Phone: 0300 123 6780  
Email: [developeras@lancashire.gov.uk](mailto:developeras@lancashire.gov.uk)  
Your ref: 3/2025/0346  
Our ref: 3/2025/0346/HDC/KW  
Date: 02 June 2026

**Location:** Dowsons Dairies Ltd Hawkshaw Farm Longsight Road Clayton le Dale  
BB2 7JA  
**Proposal:** Change of use of agricultural land to create an additional 95 car parking  
spaces.  
**Grid Ref:** 365633 432313

#### **No objection subject to conditions**

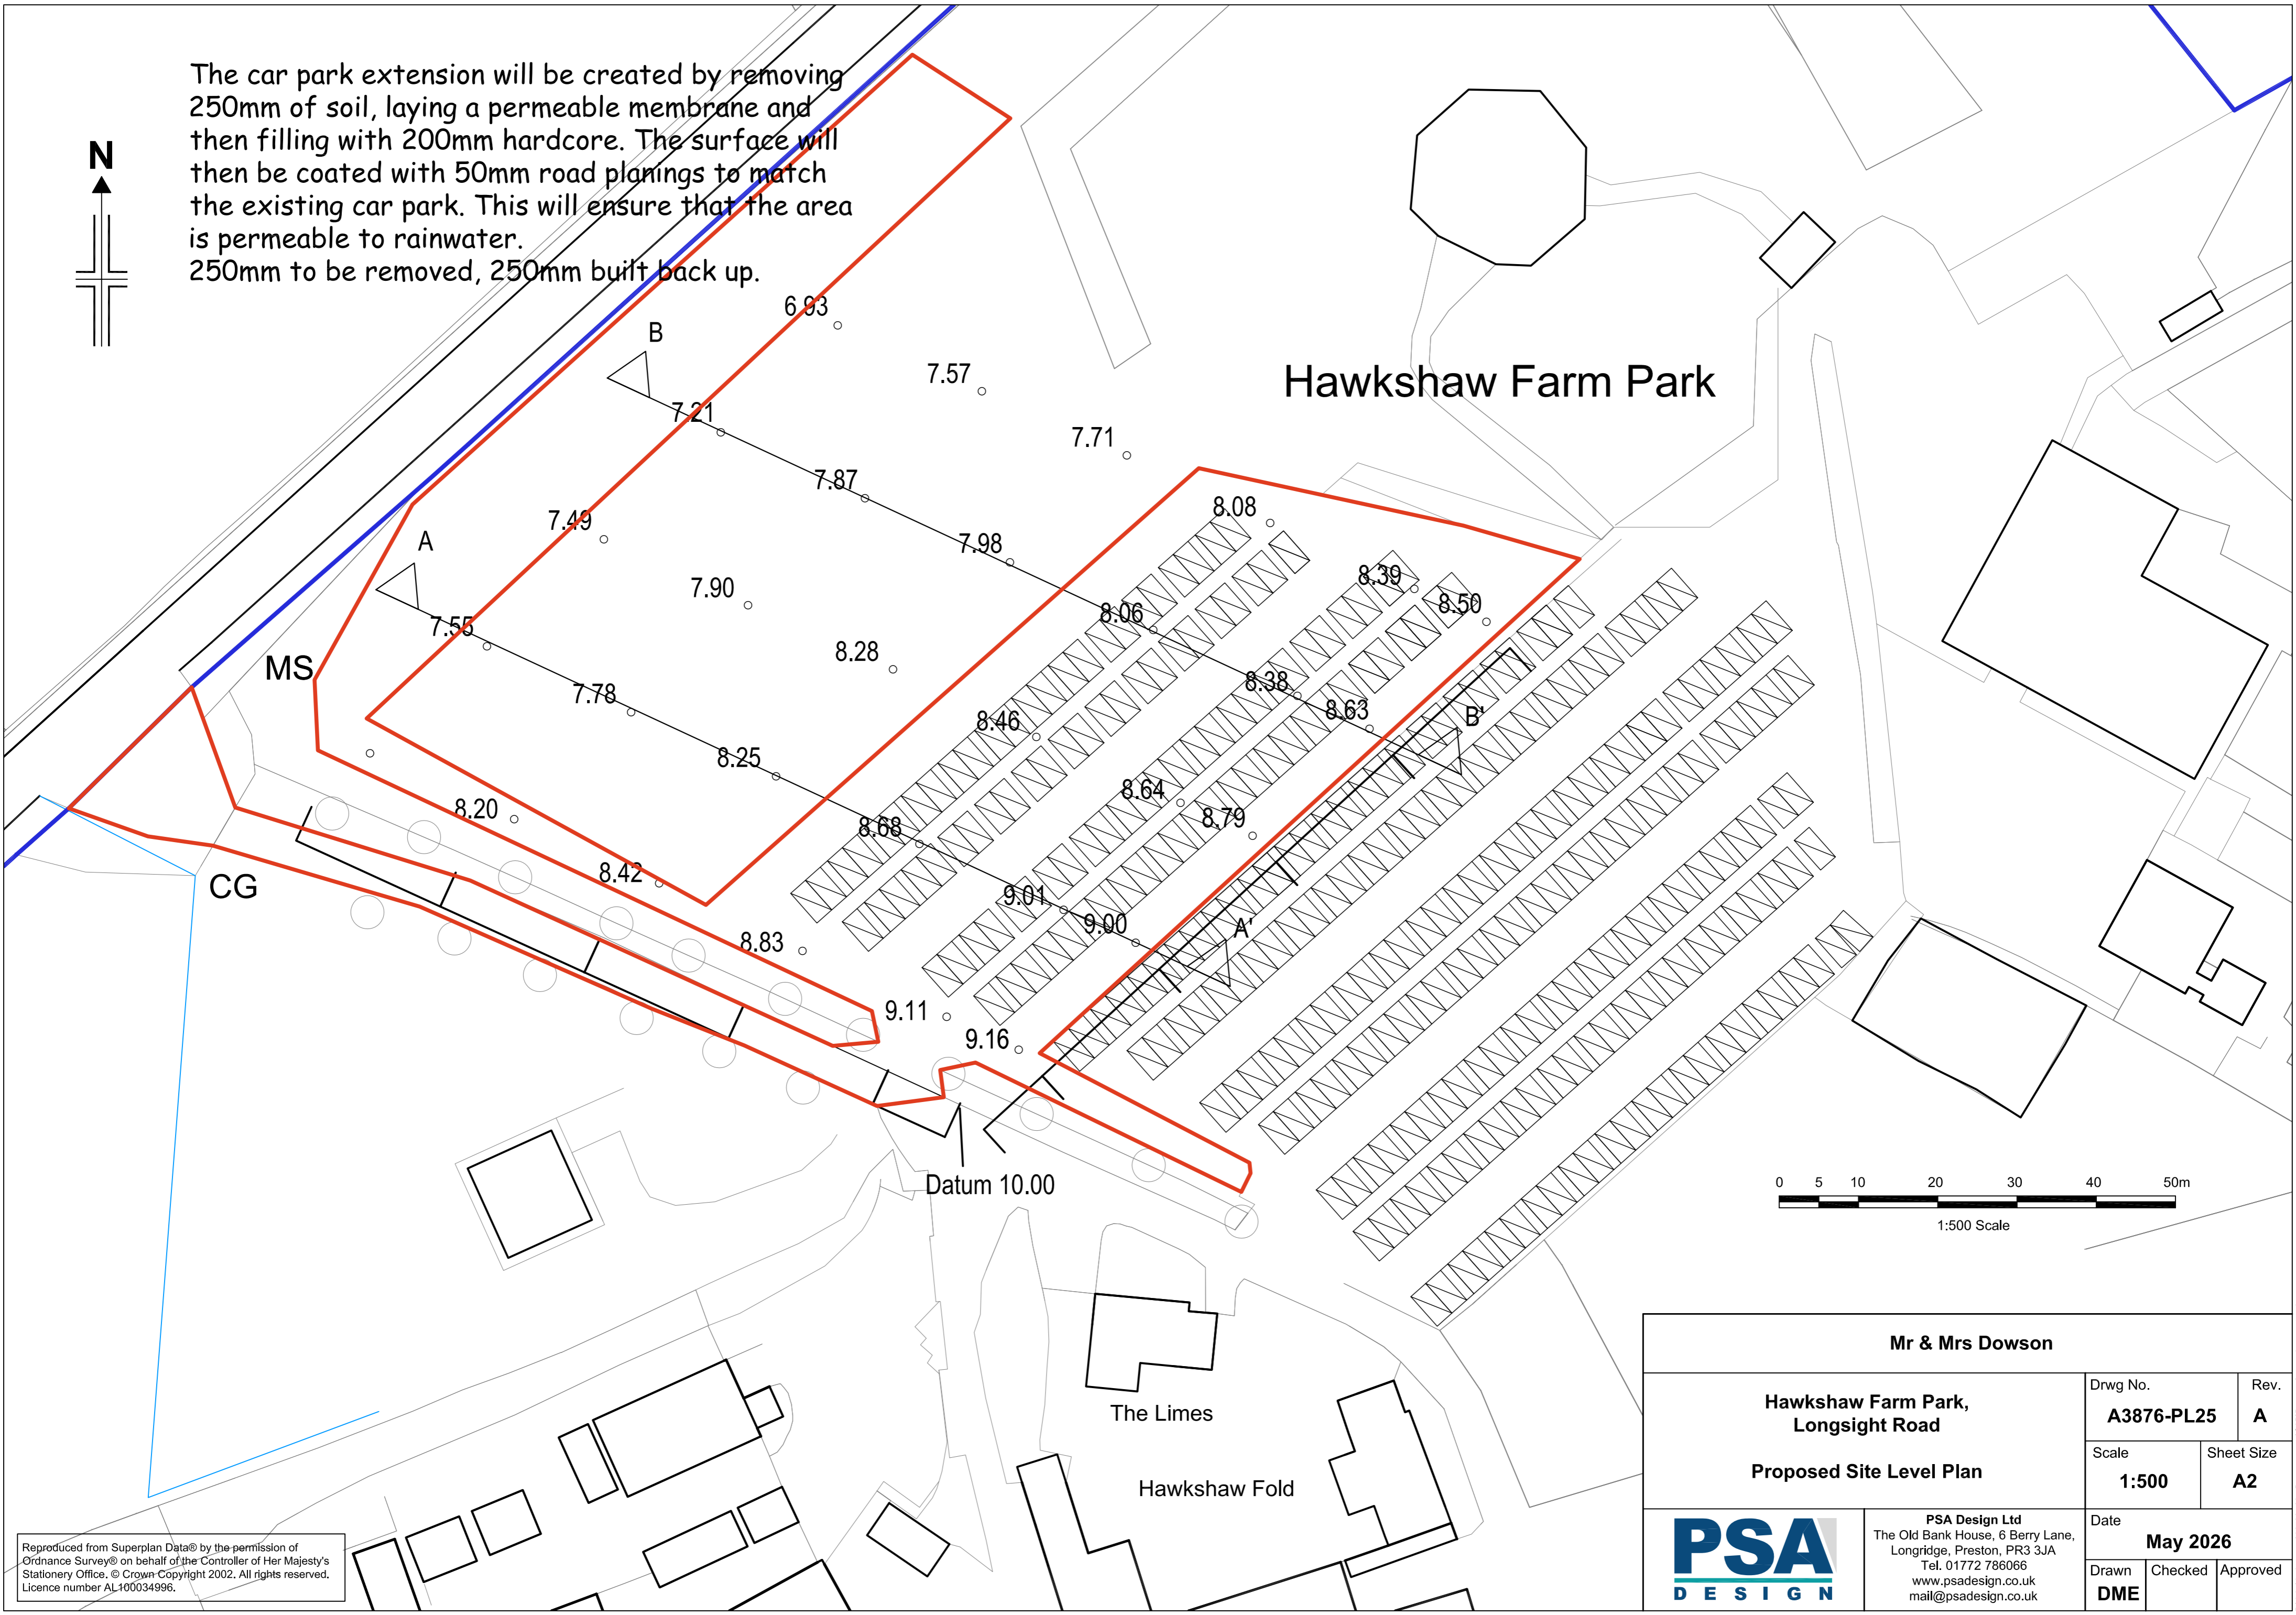
A revised site layout plan has been provided in response to the concerns previously raised by the Local Highway Authority, particularly in relation to functionality, accessibility, and overall efficiency of the parking provision. The parking layout will now be defined, with appropriate bay dimensions and the use of markers to better control parking behaviour across the site. Some bays will also be supplemented by an additional 1.2 m spacing, improving usability for the family-oriented customer base.

The inclusion of 6.0 m manoeuvring aisles ensures adequate space for vehicle turning, while the introduction of dedicated 2.0 m wide pedestrian routes through the parking rows improves safety and accessibility for vulnerable road users.

Furthermore, the addition of a one-way circulation system and clearly defined entrance and exit points provides a coherent internal traffic flow, improving both efficiency and safety.

3. No part of the development shall be brought into use until the proposed one-way circulation system within the car park, including signage and directional markings, has been implemented in accordance with drawing A2876-PL26 Rev A. The approved one-way system shall be implemented in full prior to first use of the car park and thereafter retained and maintained for the lifetime of the development.
